# Outer Dowsing Offshore Wind

## Schedule of Changes for Plans

### Deadline 3

Document Reference: 3.0

Sheet 32

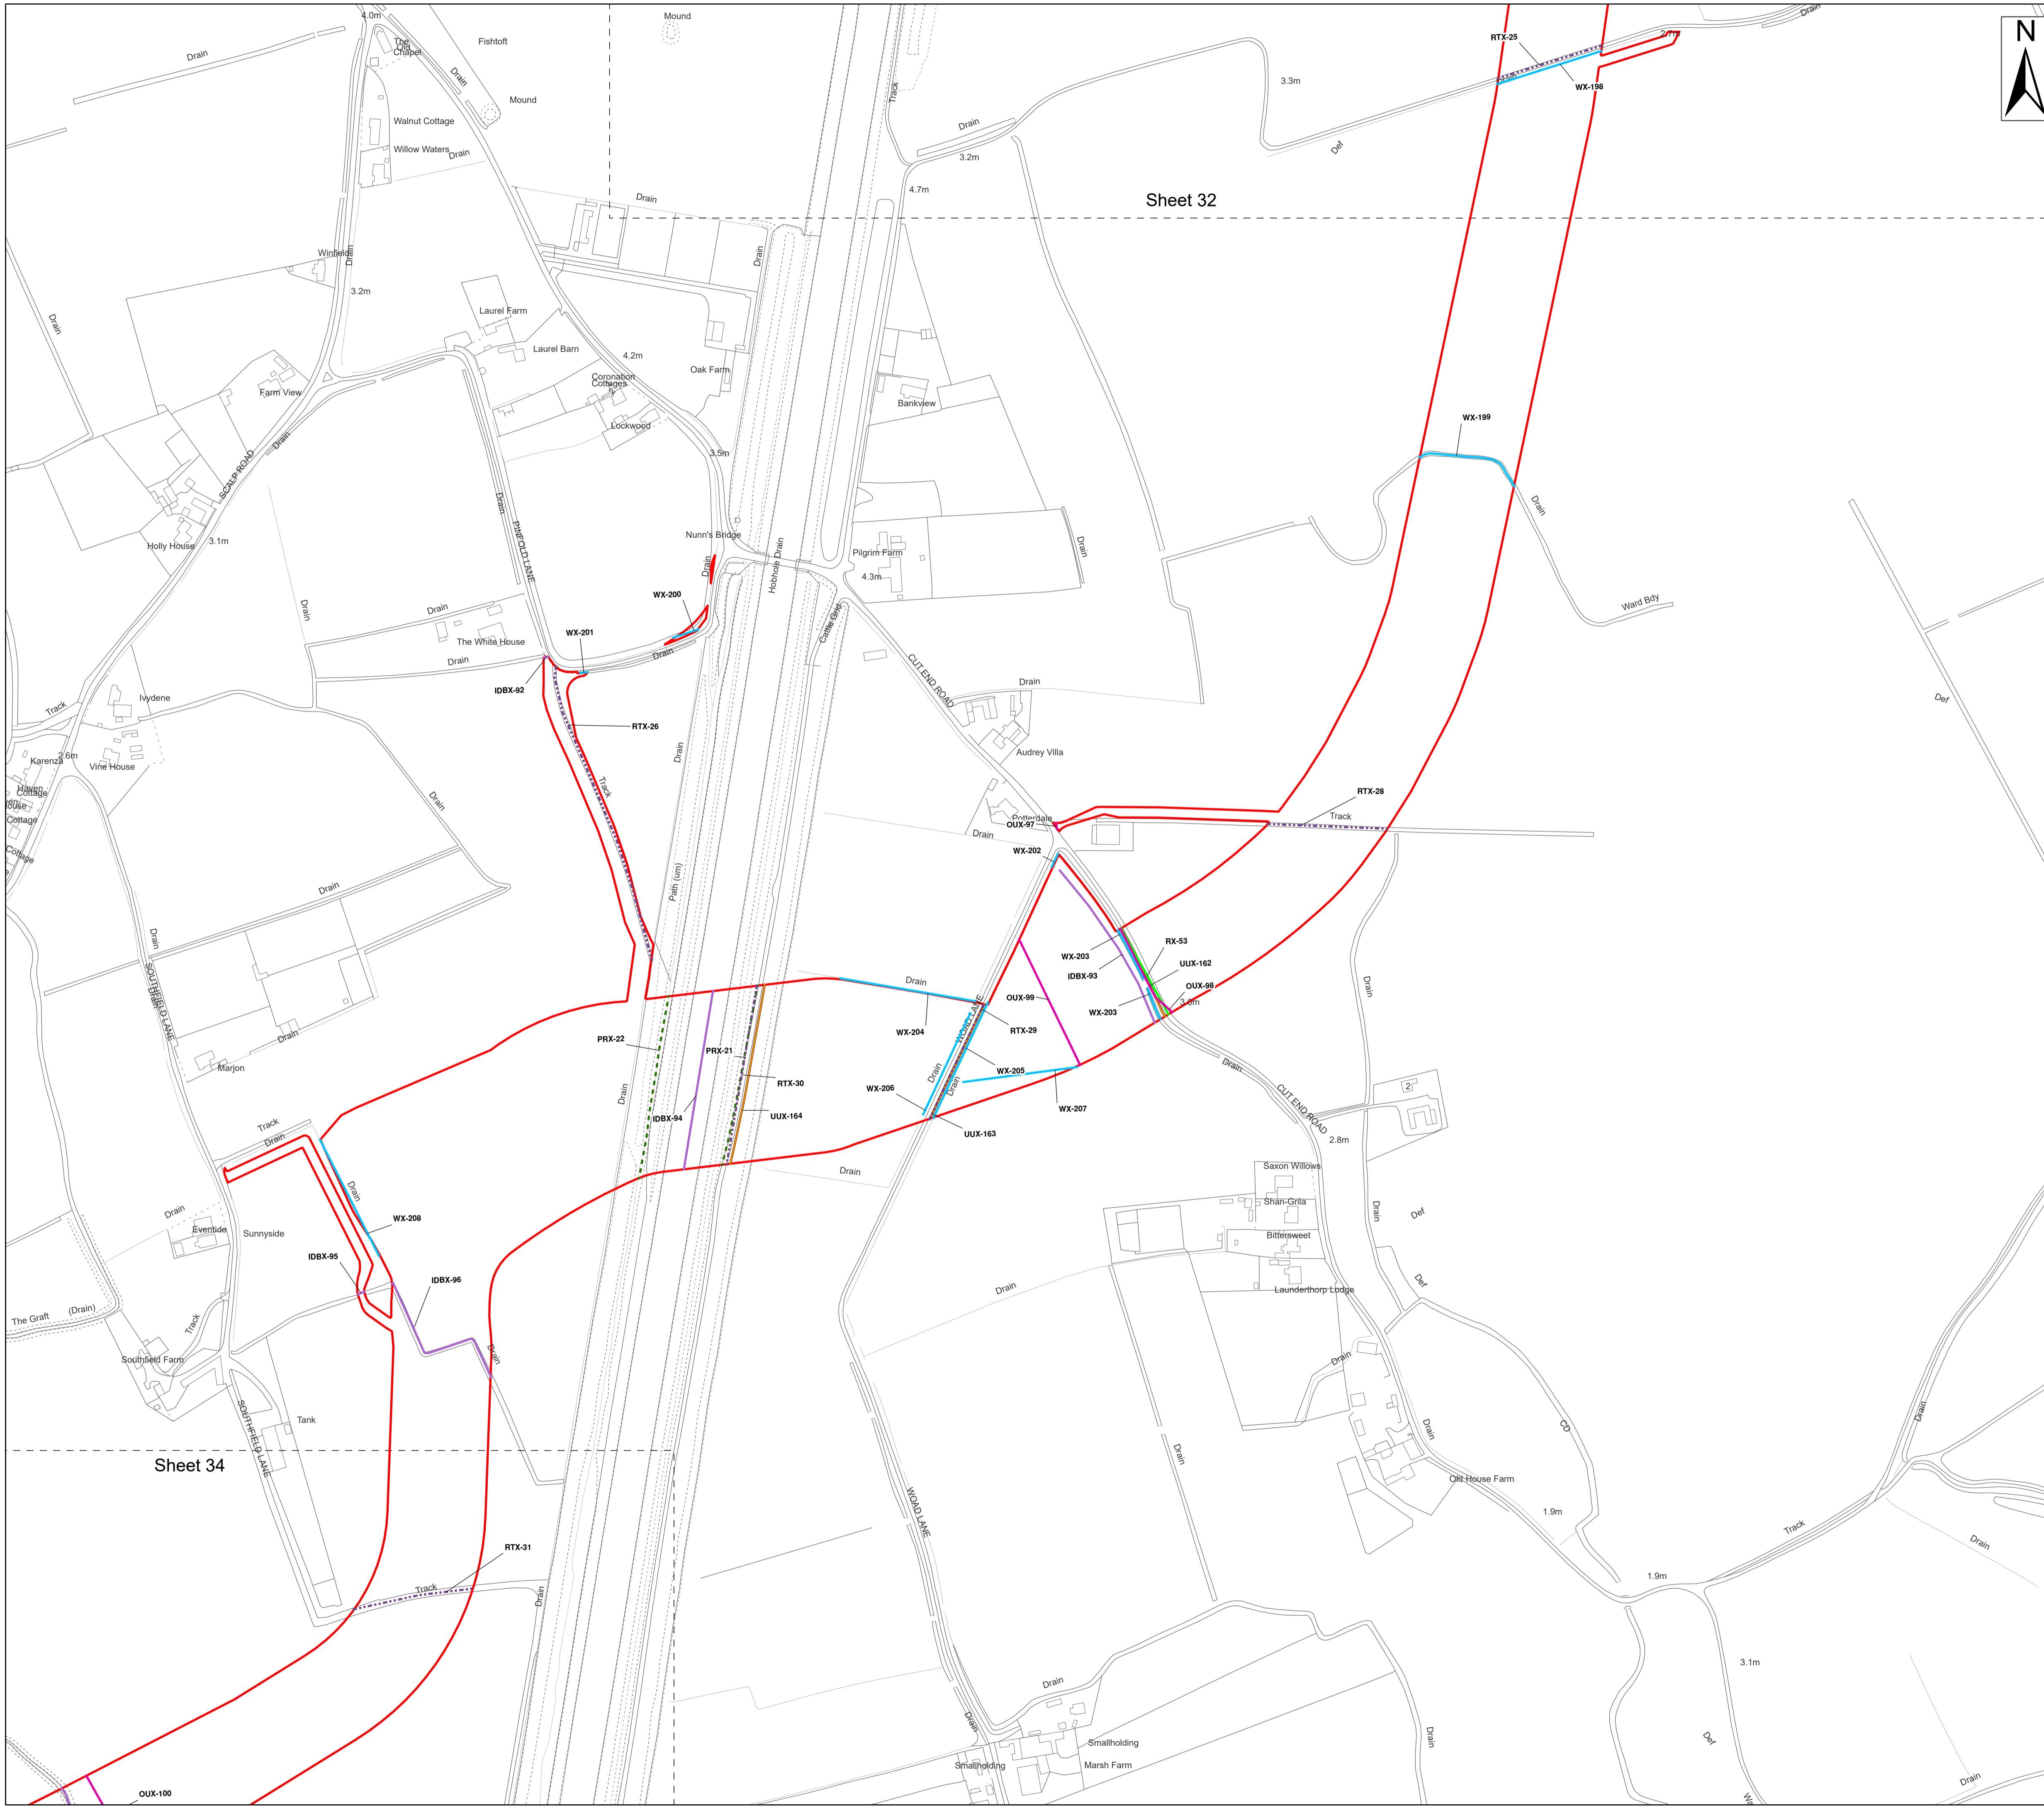
Plan sheet number	Crossing Reference (Plan 2.18)	Plan PROW Plan Reference (Plan 2.10)
31	PRX-20a	OMC B/24/0191 between points OMC36 and OMC 37
32	PRDX-4	Diversion between points CTD9 and CTD10
32	PRX-20b	CTD B/24/0197 between points CTD9 and CTD10
32	PRDX-5	Diversion between points CTD11 to CTD12
32	PRX-20c	CTD B/24/0197 between points CTD11 and CTD12 and OMC B/24/0197 between points OMC38 and OMC39
33	PRX-20d	OMC B/24/0198 between points OMC40 and OMC41
33	PRX-20e	CTD B/24/0198 between points CTD13 and CTD14 and OMC B/24/0198 between points OMC42 and OMC43
33	PRDX-6	Diversion between points CTD13 and CTD14

2.10	N/A	November 2024	V4	Updated to remove proposed public rights of way following consultation with LCC.	Removal of previously shown proposed PROWs and associated diversions. Removed from: Sheet 31: OMC B/24/0191 Sheet 32: CTD B/24/0197, OMC B/24/0197 Sheet 33: OMC B/24/0198, CTD B/24/0198
<b>2.18 Onshore Crossing Plan</b>

2.18	N/A	November 2024	V4	Updated to remove proposed public rights of way following consultation with LCC.	Removal of previously shown proposed PROWs and associated diversions. Removed from: Sheet 31: PRX-20a, Sheet 32: PRDX-4, PRX-20b, PRDX-5, PRX-20c, Sheet 33: PRX-20d, PRX-20e and PRDX-6.
